Comment for planning application 21/03164/OBL

| Proposal | <input type="text" value="Discharge of golfing obligations associated with the Second Schedule to the Great Wolf Resort s106 (19/02550/F)."/> |

Planning Application - 21/03164/OBL

Discharge of golfing obligations associated with the Second Schedule to the Great Wolf Resort s106 (19/02550/F).

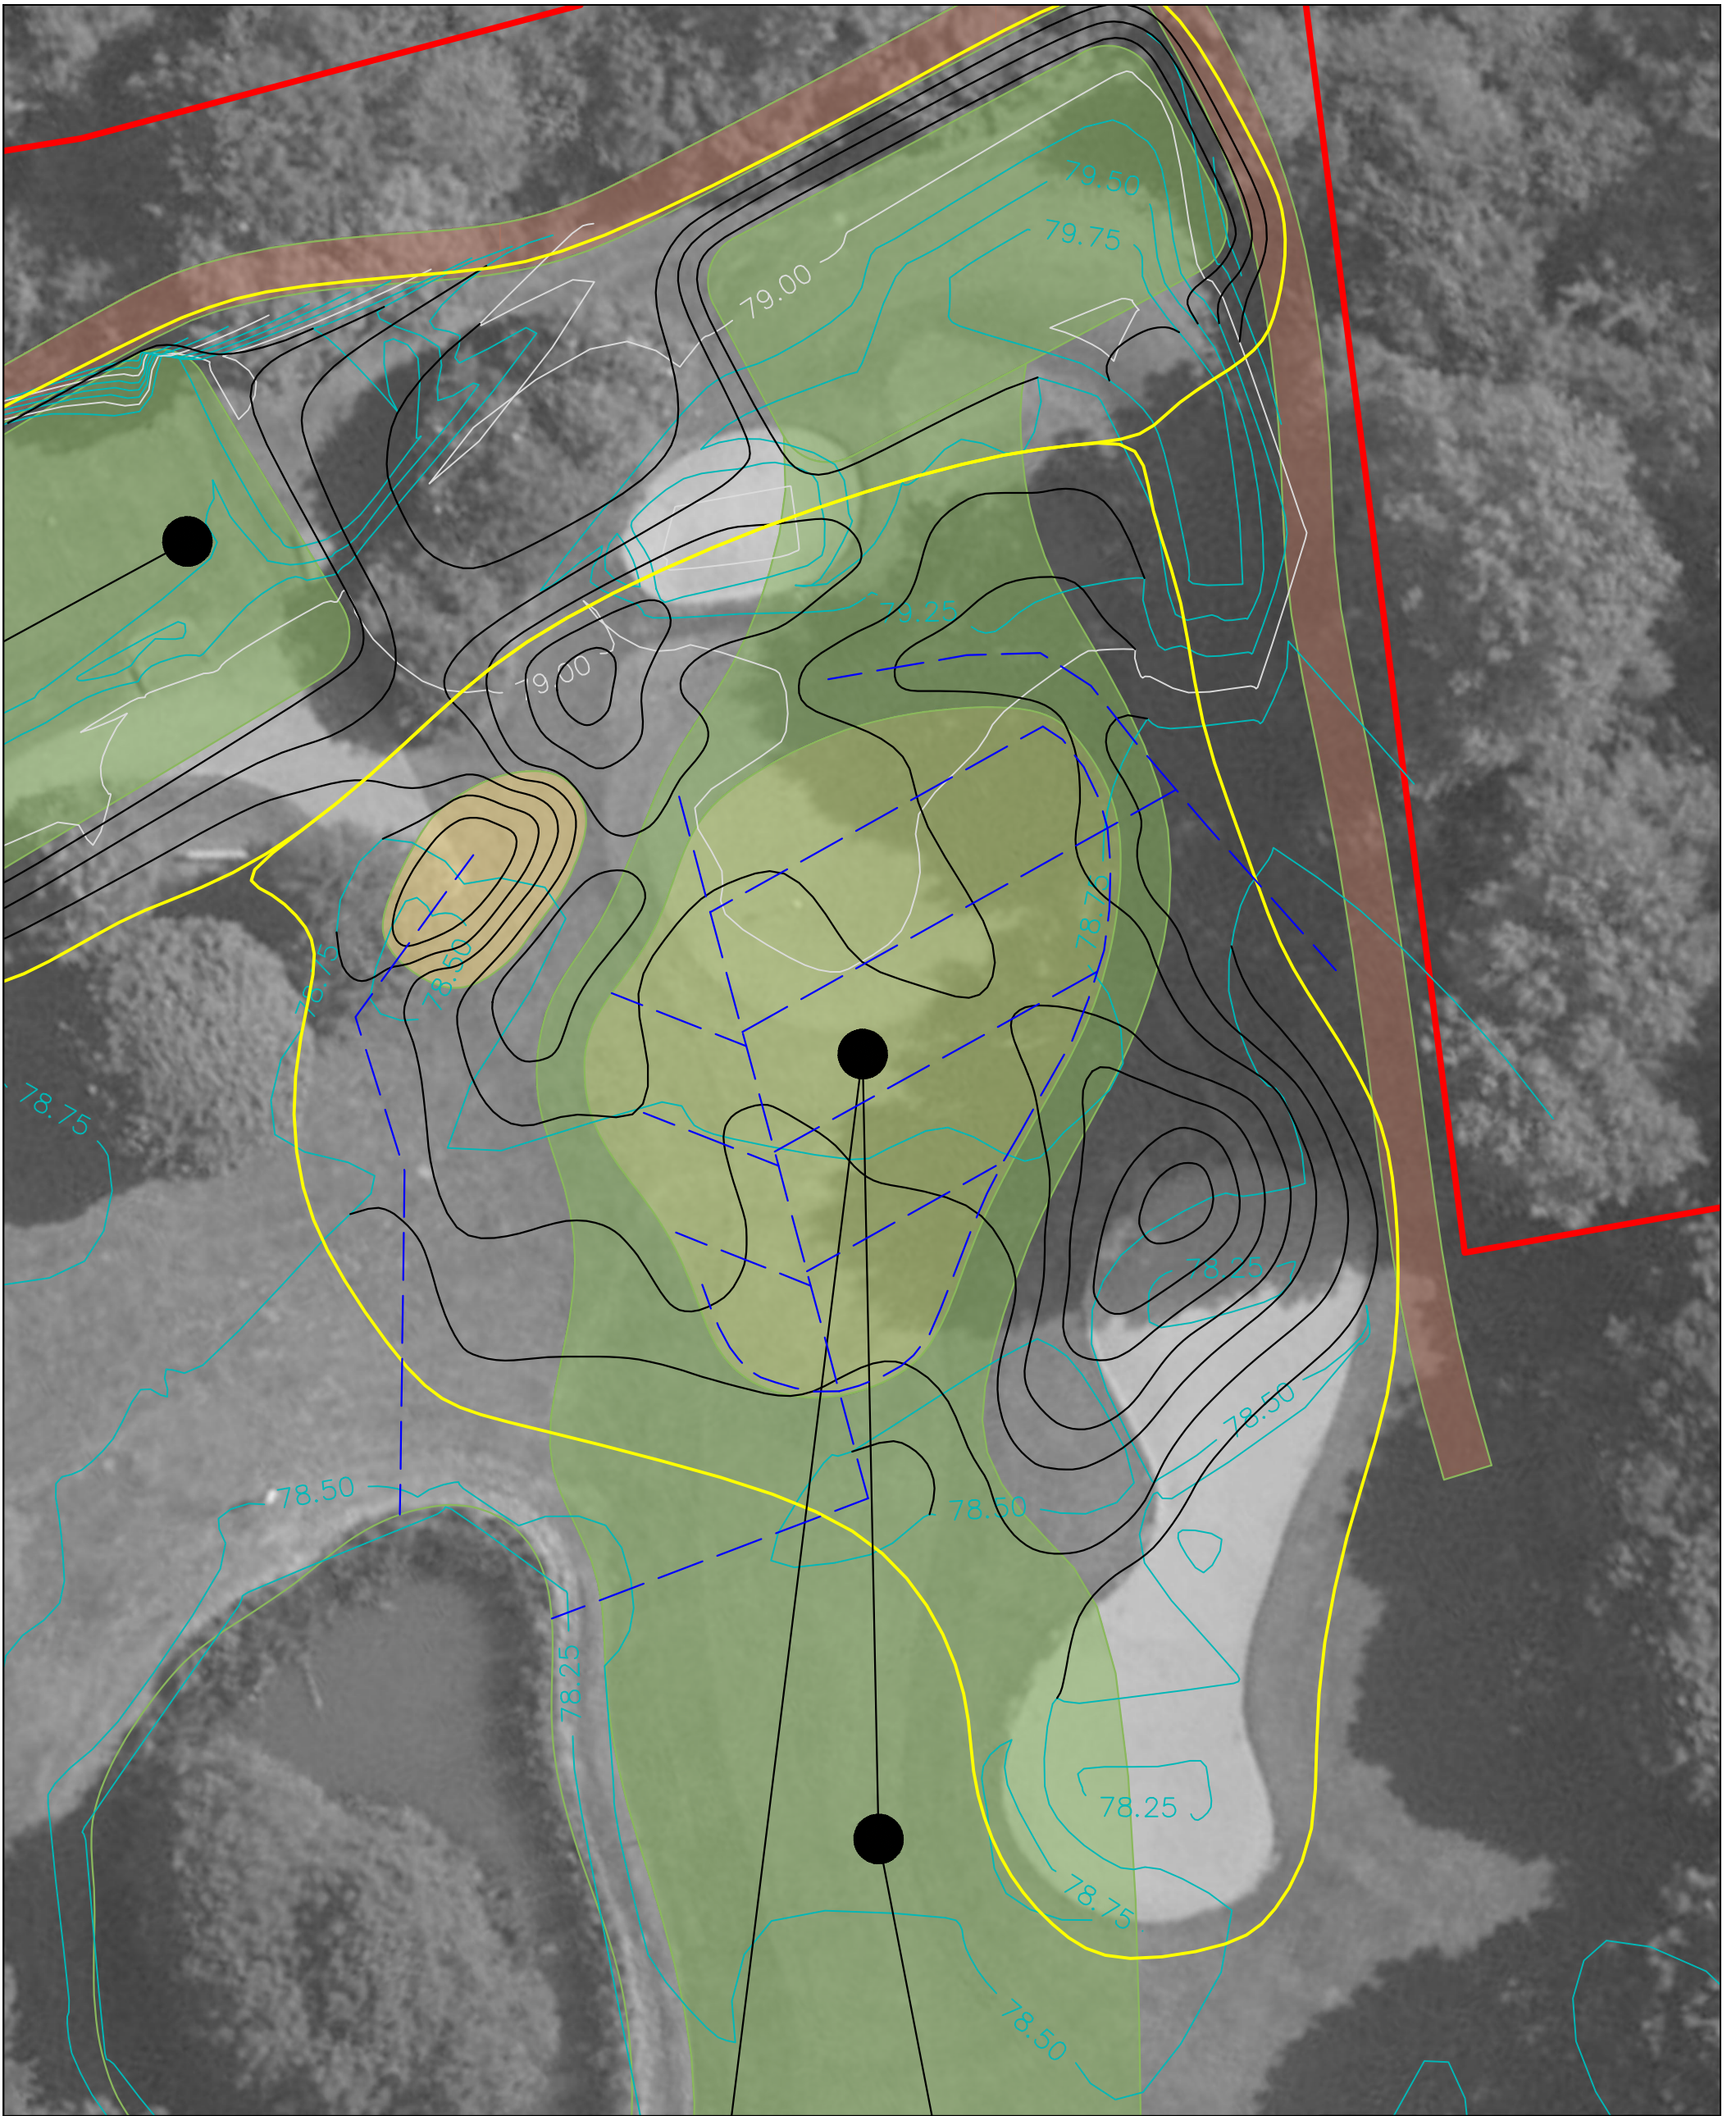
EIGCA guidelines suggest a 40-60 m boundary from green to boundary, hence my concern about safety fencing required to protect golfers walking from the new 1st Green to the new 2nd tee.

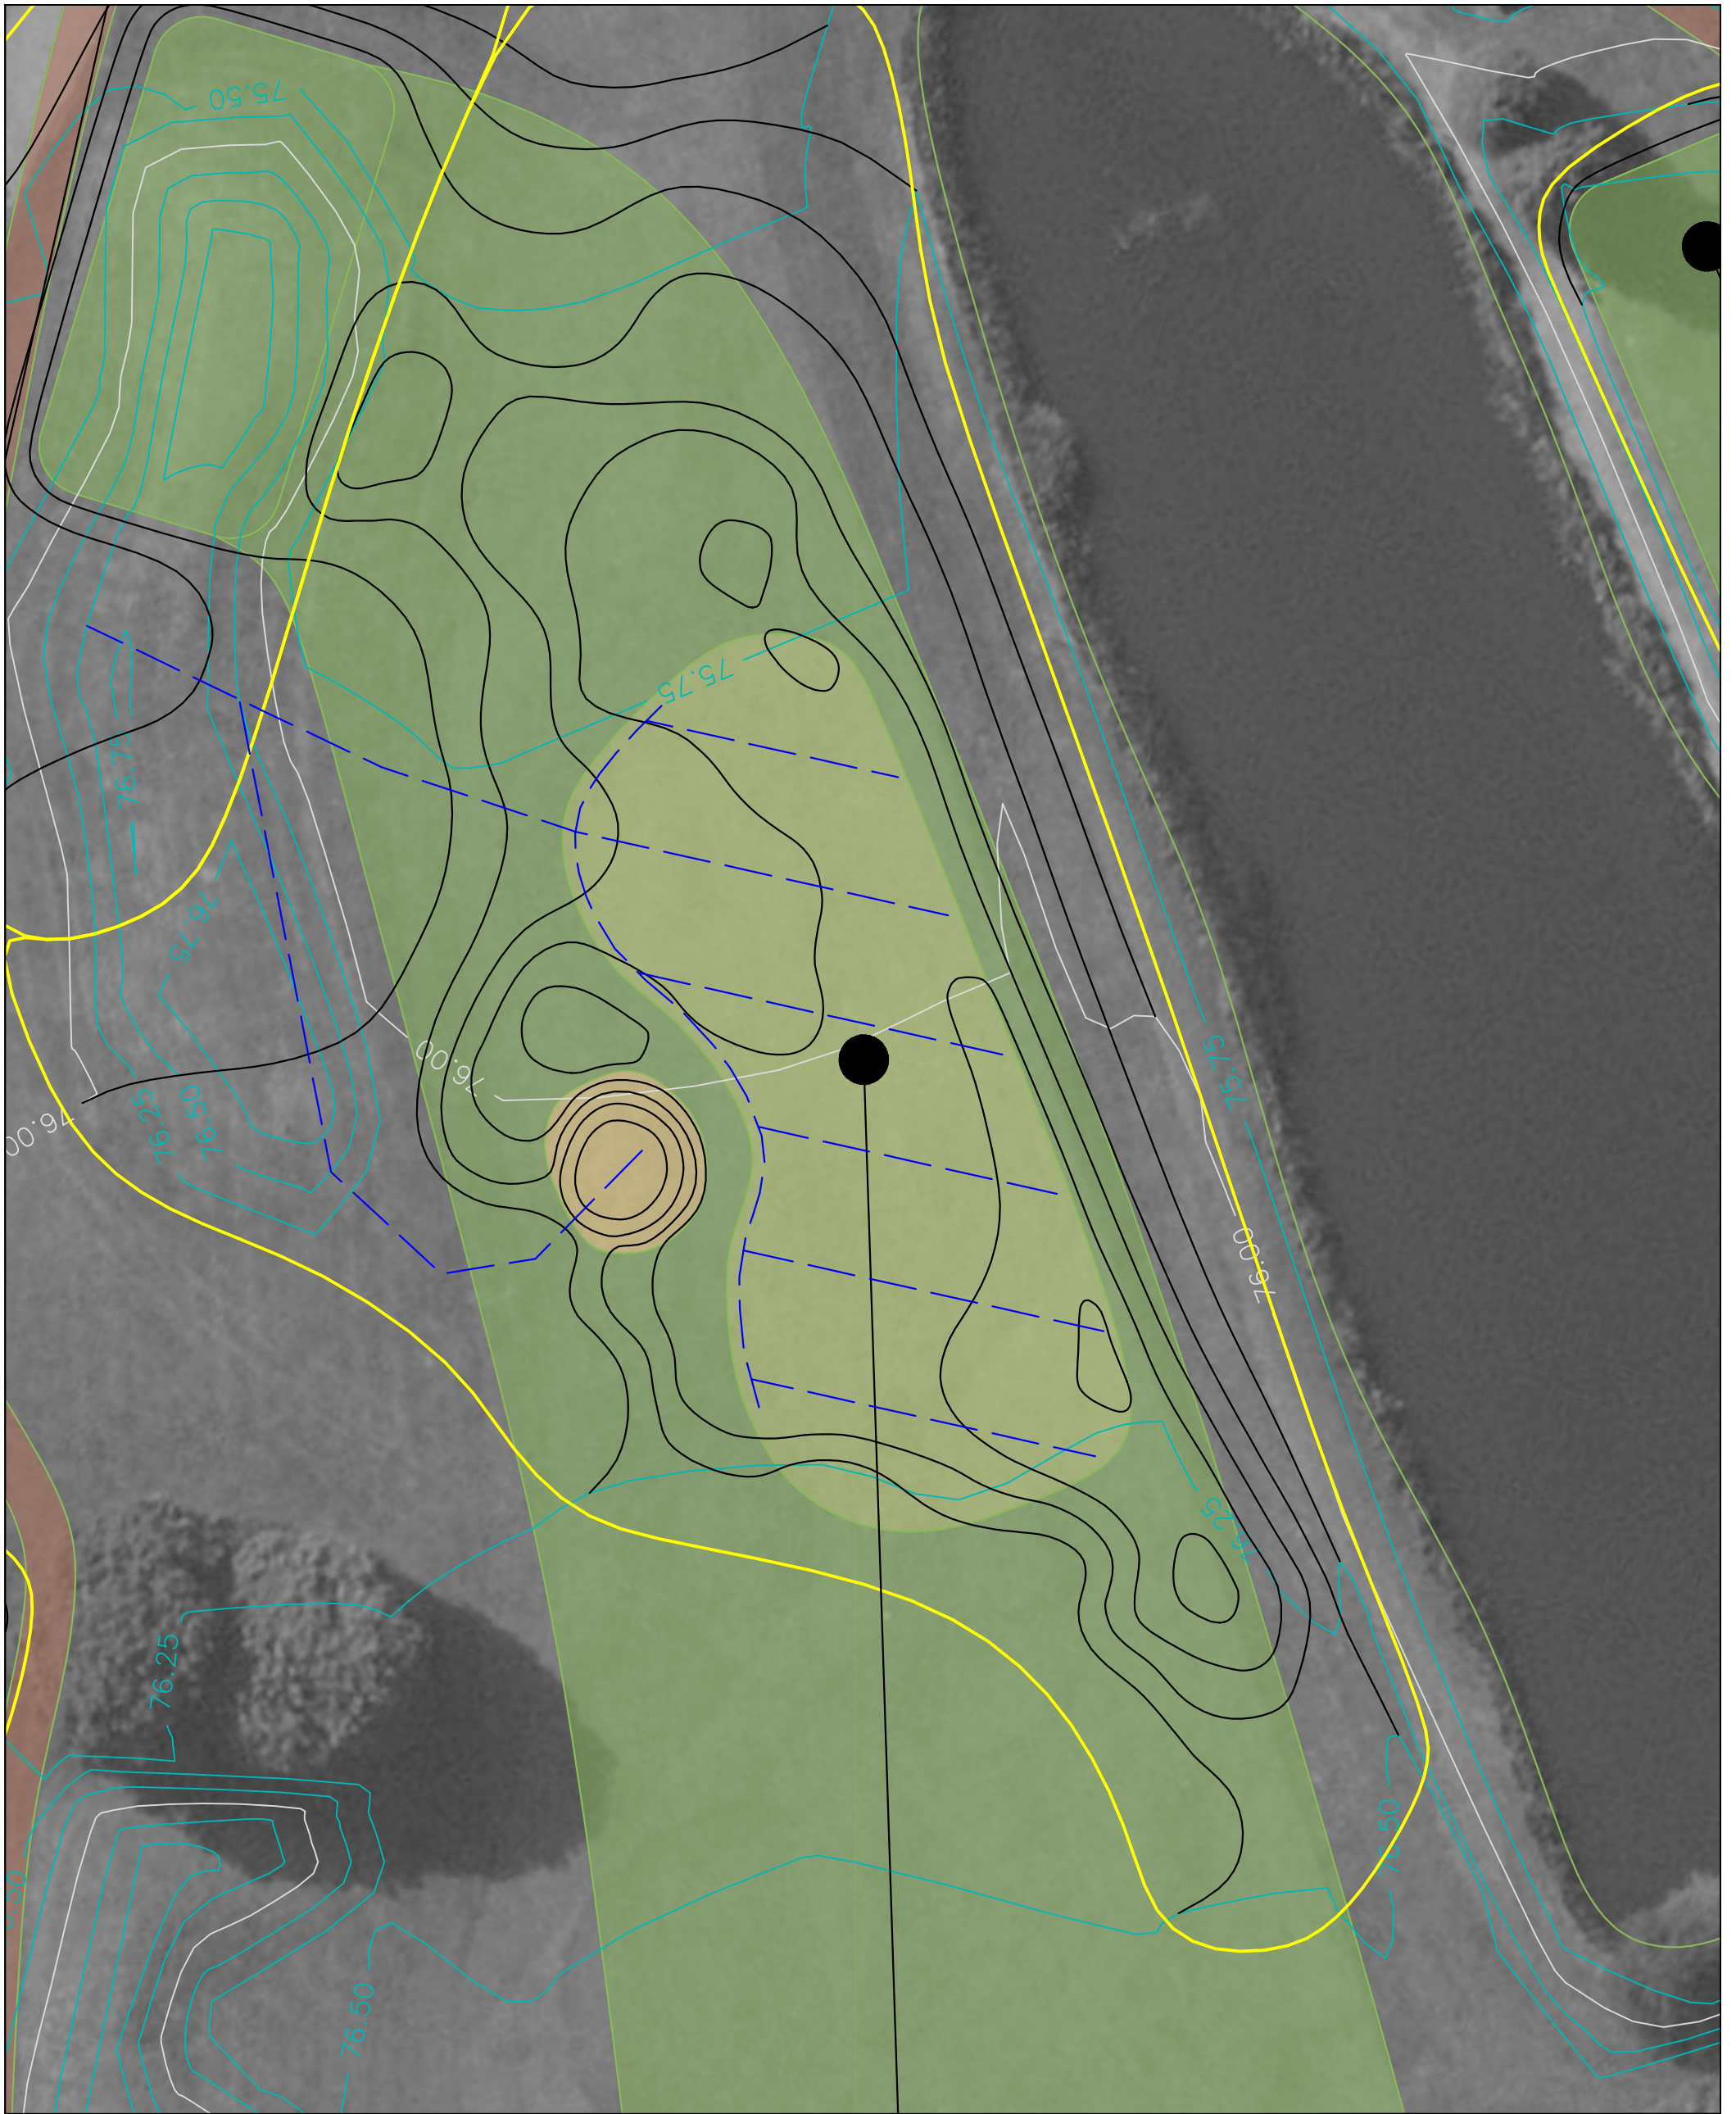
Swan Design have not addressed my question about driving from the new 9th back-tee with the close proximity of the new 8th green.

I refer to a golf safety report by Swan Design at North Shore Golf Club between Skegness and Mablethorpe. See link below. In the report, Swan Golf Design say the golf ball danger zone is either side of a 220m line drawn towards the green from the tee, with a 60m zone either side of the 220m mark and 30m either side of the tee. Could the Golf Course designer kindly annotate on a drawing, where they consider the golf ball danger zone is in relation to the new 8th green, when driving off the new back 9th tee?

Playability of the new 8th green due to its proximity to water

My comments in my previous letter have been mis-read. The comments were about the new 8th Green, not the 3rd and are very valid.
